PLANNING & COMMUNITY DEVELOPMENT DEPARTMENT  
Land Use Review Division

Revised 12/22/2021 – 2<sup>nd</sup> Review

**RE: Vue De La Parc Apartments – Development Plan and Nonuse Variance – 2<sup>nd</sup> Review Comments**

**FILE: AR DP 21-00368 and AR CNV 21-00369**

8 TYPICAL REDI-ROCK RETAINING WALL SECTION
NTS

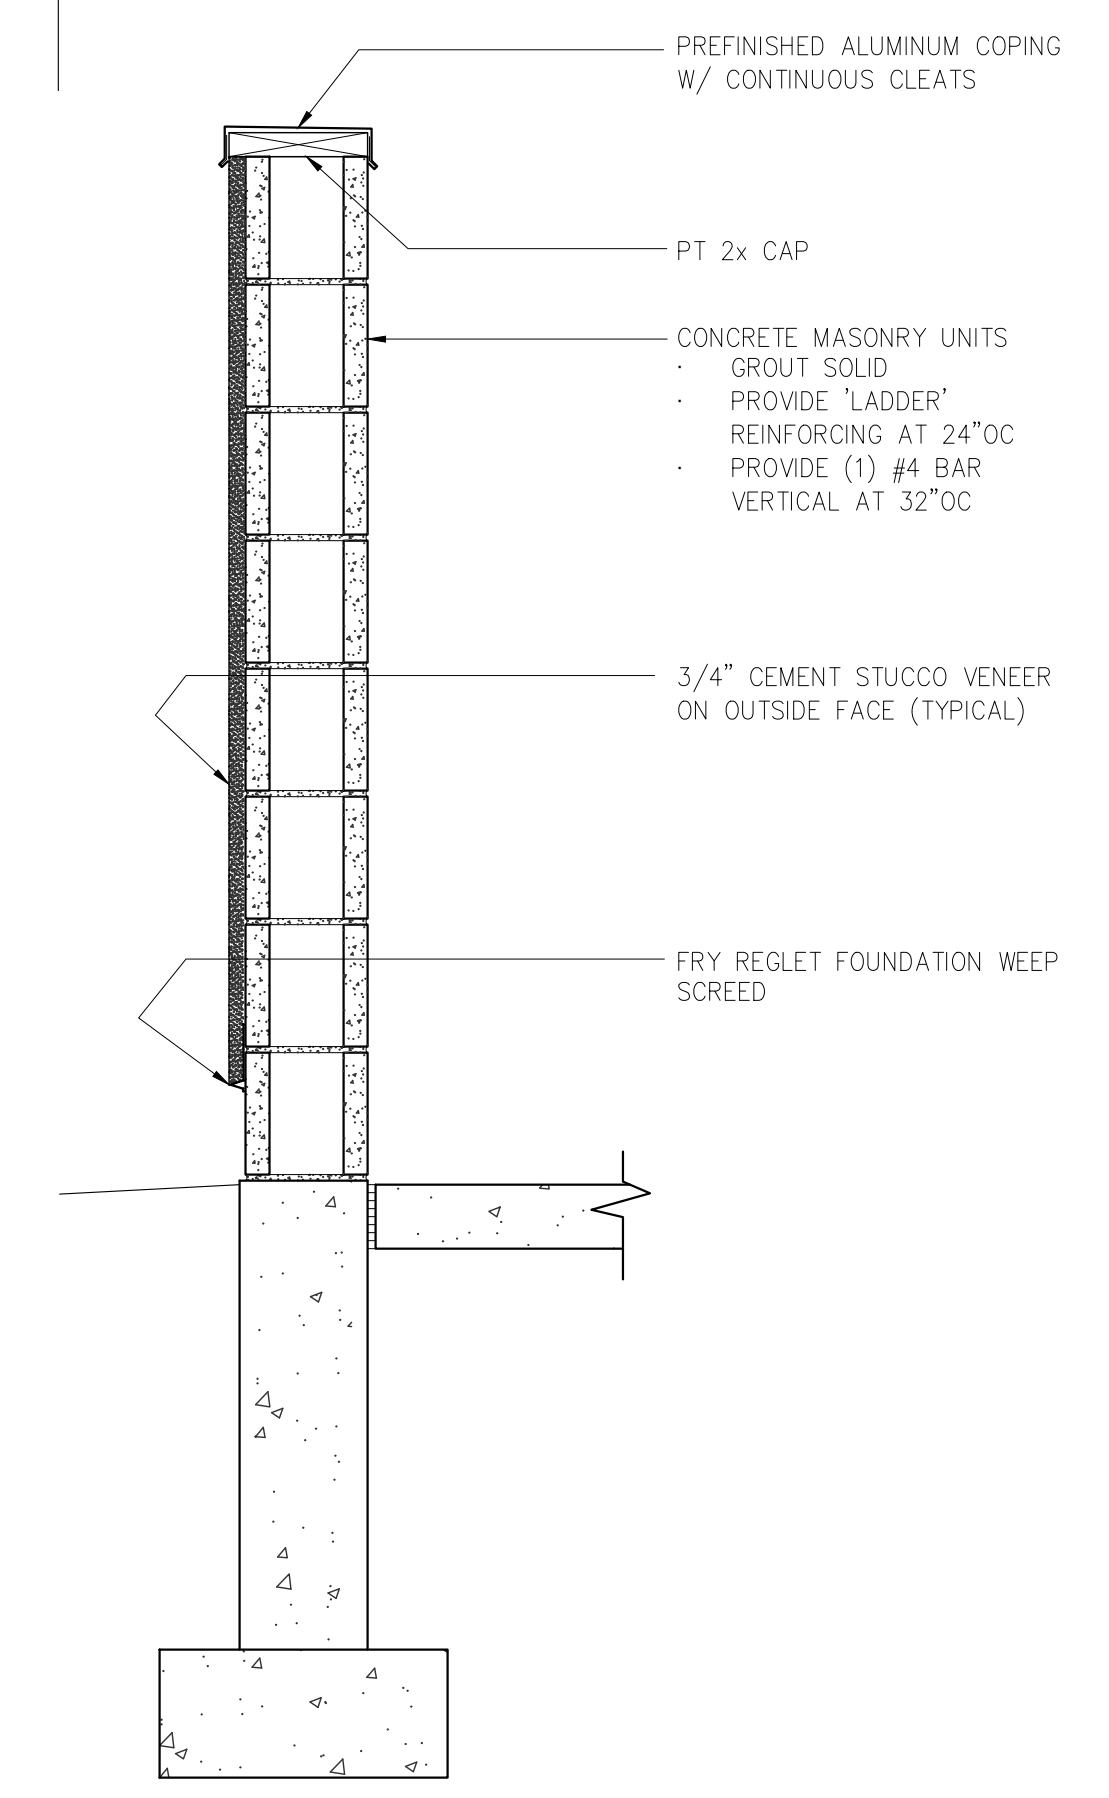
9. Please provide the type, materials, size and height with detailed exhibits of all fences and retaining walls. Please include details of pilasters and the distance between each. Perimeter retaining walls shall include pilasters within a reasonable distance to avoid long devoid walls. **New Note: Please add fence/wall information to plan set. Redi-Rock Retaining Wall Detail shown on detail 8 page 3 of 9.**

- e. Provide general retaining wall heights on the plans and provide a detail of the retaining wall. (PLP check #1i). If needed, are any guardrails planned for the site due to falls adjacent to walks? **Partly addressed – provide a detail of the proposed retaining wall, staff did not see one in the set.** Detail of Redi-Rock Retaining wall added to sheet 2 of 9.

5 TRASH ENCLOSURE ELEVATIONS
1/4" = 1'-0"

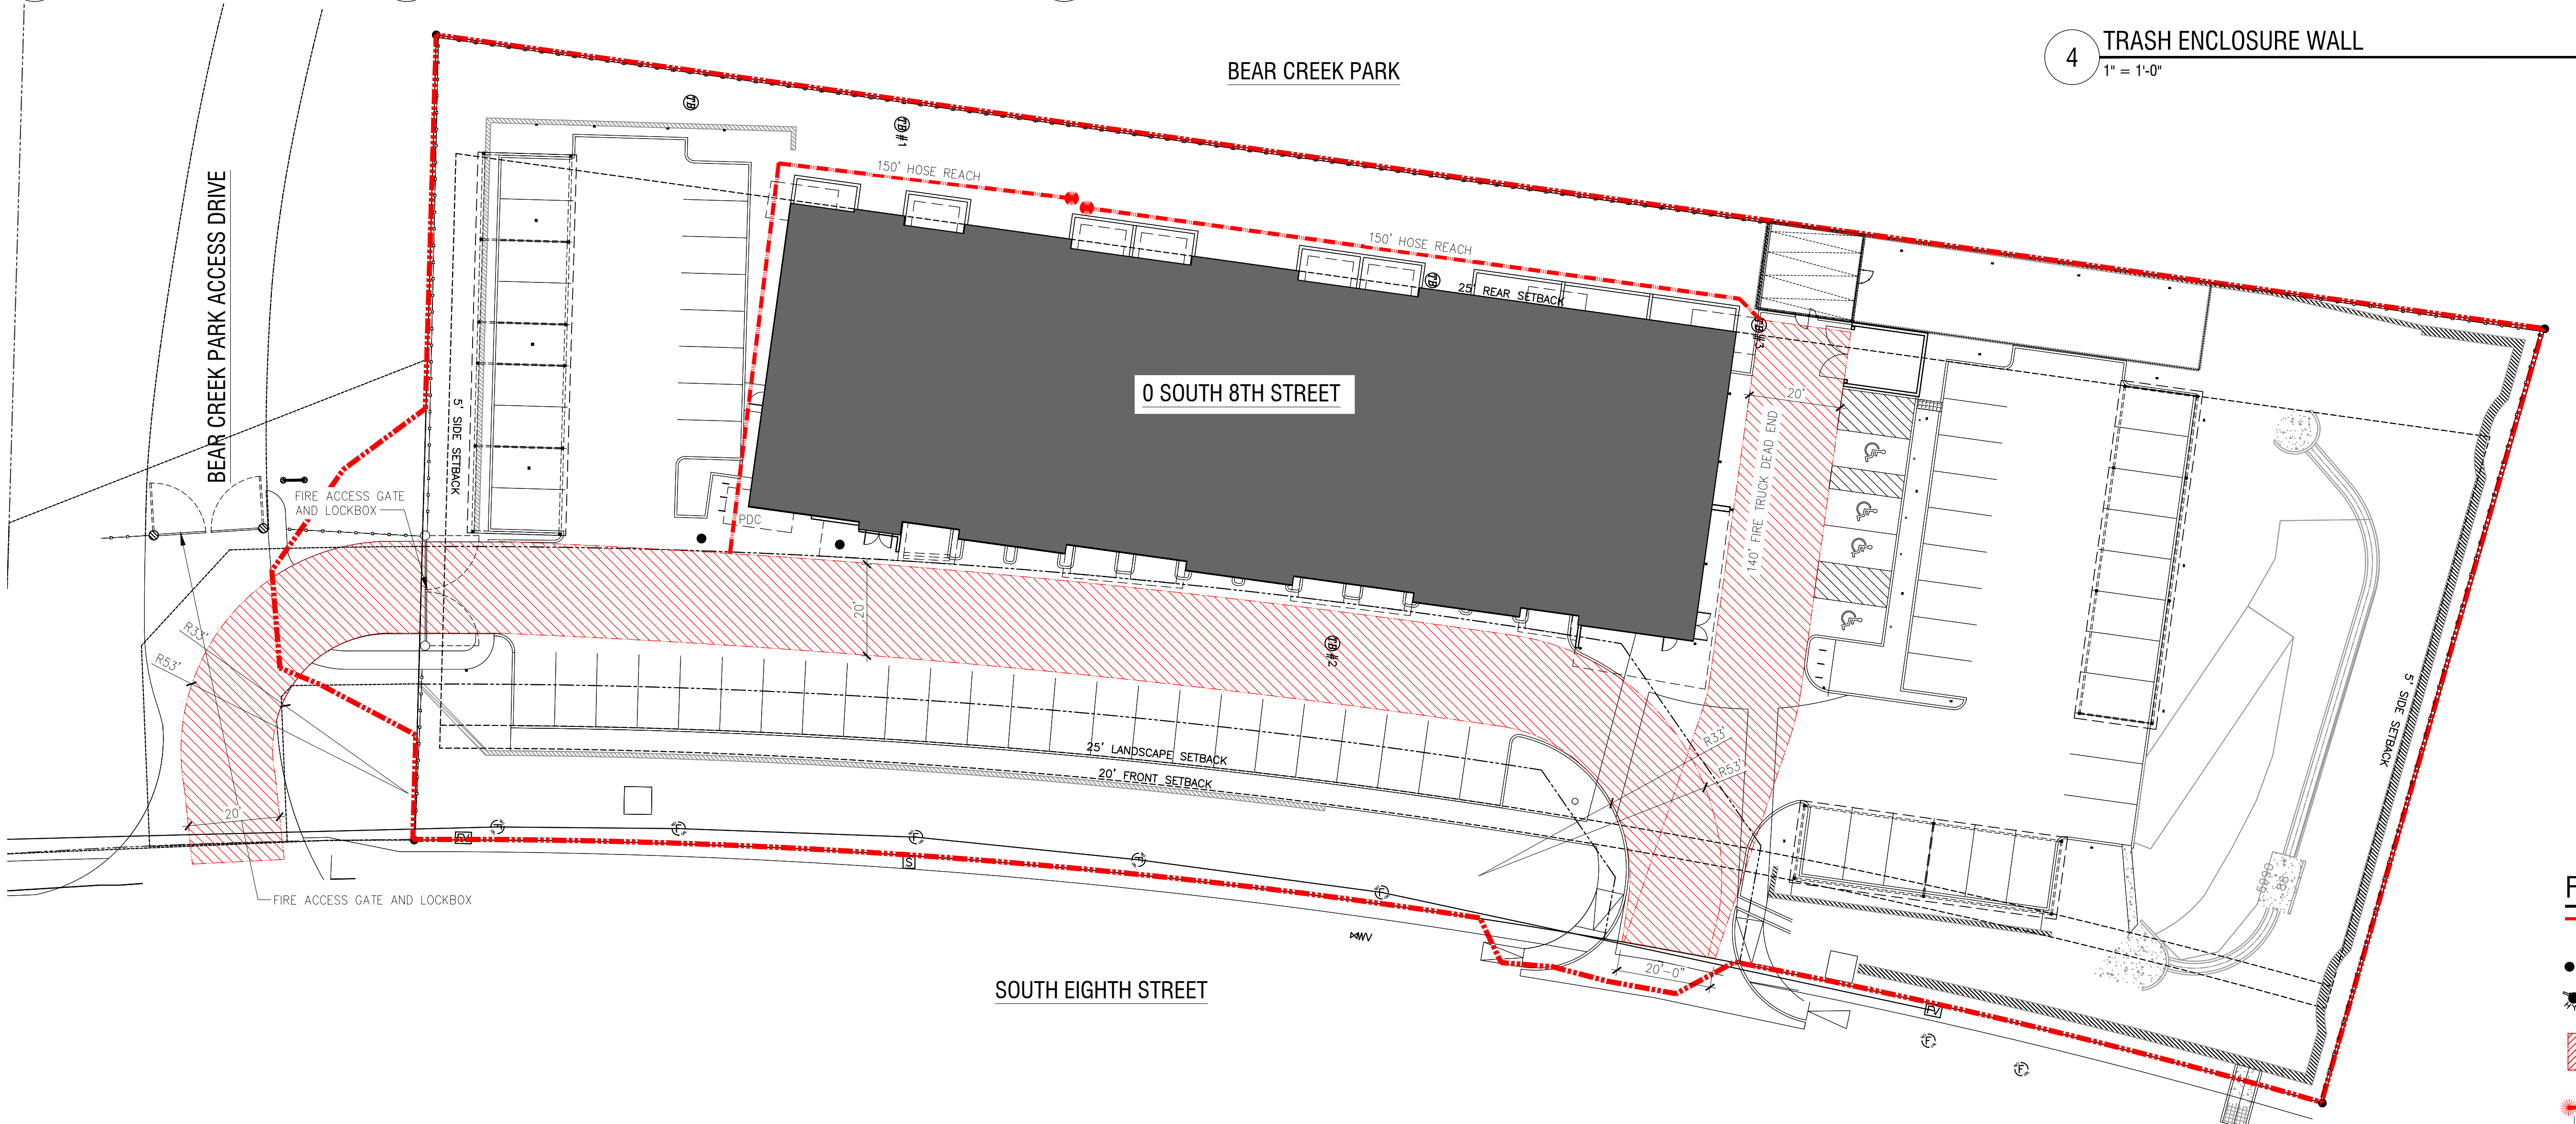
4. Please provide a roof top trellis for the proposed trash enclosures to prevent wind-blown debris.
5. Please provide a photometric plan.
6. Please provide an elevation view of all site exterior light fixtures including freestanding and those attached to the free-standing building.

FINAL LANDSCAPE PLAN

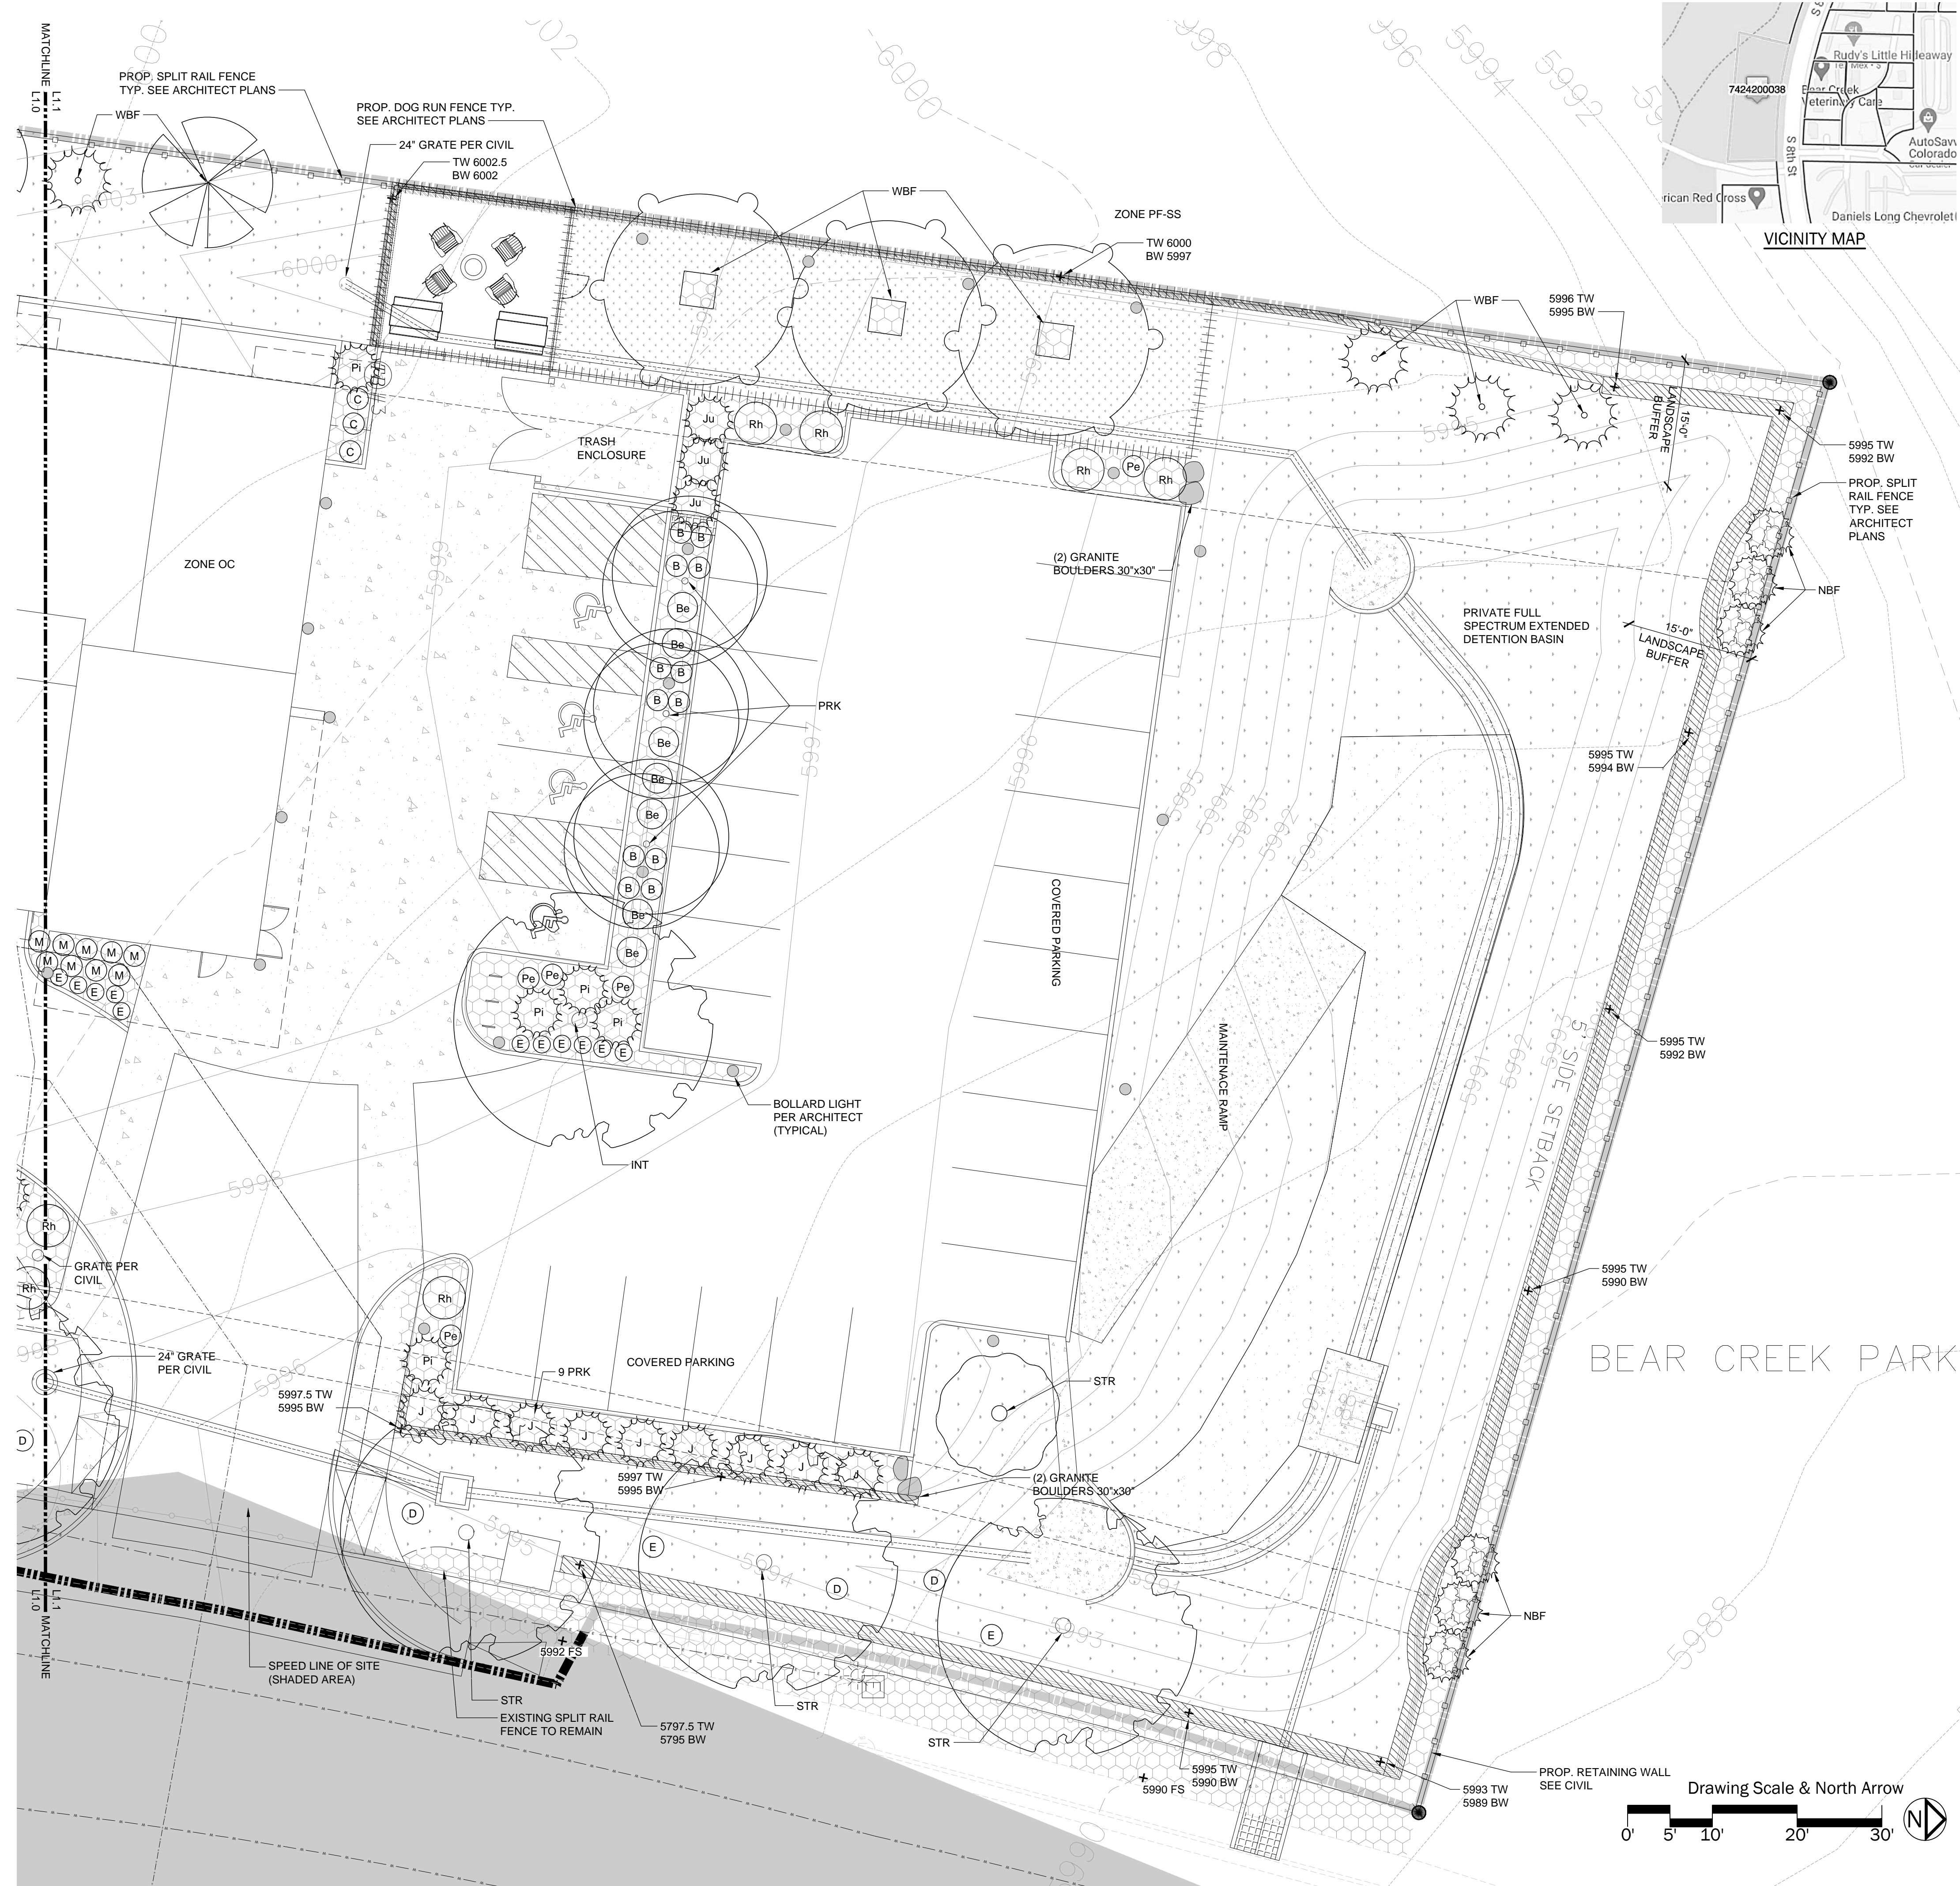
- d. Label and dimension the required 25' setback along 8<sup>th</sup> street. (PLP check #1h) **New comment – update the landscape plans to match the engineering sheets in the set, it looks like a sidewalk is planned between the curb and retaining wall and the landscape setback would not be located in the parking lot (motor vehicle lots should not be located within the landscape setback - 7.4.320.B.Policy 320.5). Updated**

1. Reviewed by Kimley-Horn on behalf of SWENT.
2. Repeat comment: label detention facility as "Private Full Spectrum Extended Detention Basin". This label needs to appear on the landscape plan as well. **Labeled**
3. Show the proposed maintenance path on the landscape plans. **Added**
